**The Potting Barn
No.5 Hobbs Court
Bilsham Rd.
Yapton**

Ref. Application **Y/35/26/PL** for Little Meadow Bilsham Rd. Yapton
West Sussex BN18 0JY

Proposal: The erection of 1 No. detached self-build dwelling to
replace existing caravan.

OBJECTION

Winter Groundwater Monitoring

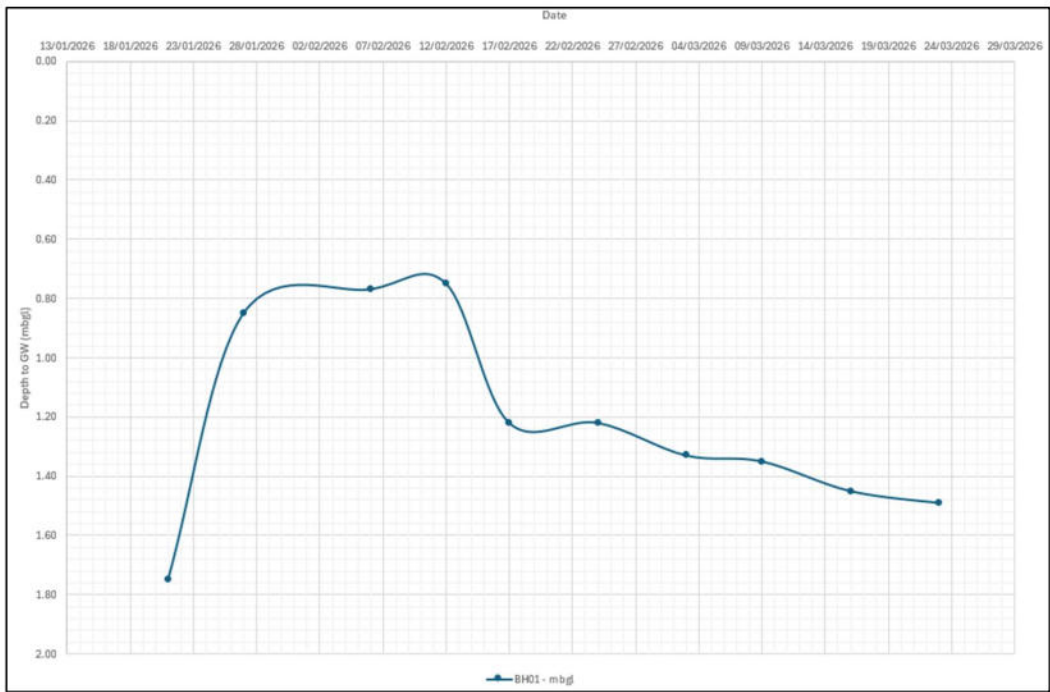
The details submitted by consultants for the applicant, 'Land Science', 30th March 2026, refers to the site as in Flood Risk Area 1. The winter monitoring table shows the high-water level, as approx. 2ft.3 inches-(70 cm.) Blg, which cannot be ignored in association.

i) It also conflicts with the policy that any SuDS treatment must be freeboard at the base by 1m. The applicant's own assessors confirm approx. 2ft. 3 in(70cms.) which would render any SuDS treatment below the required freeboard as obsolete.
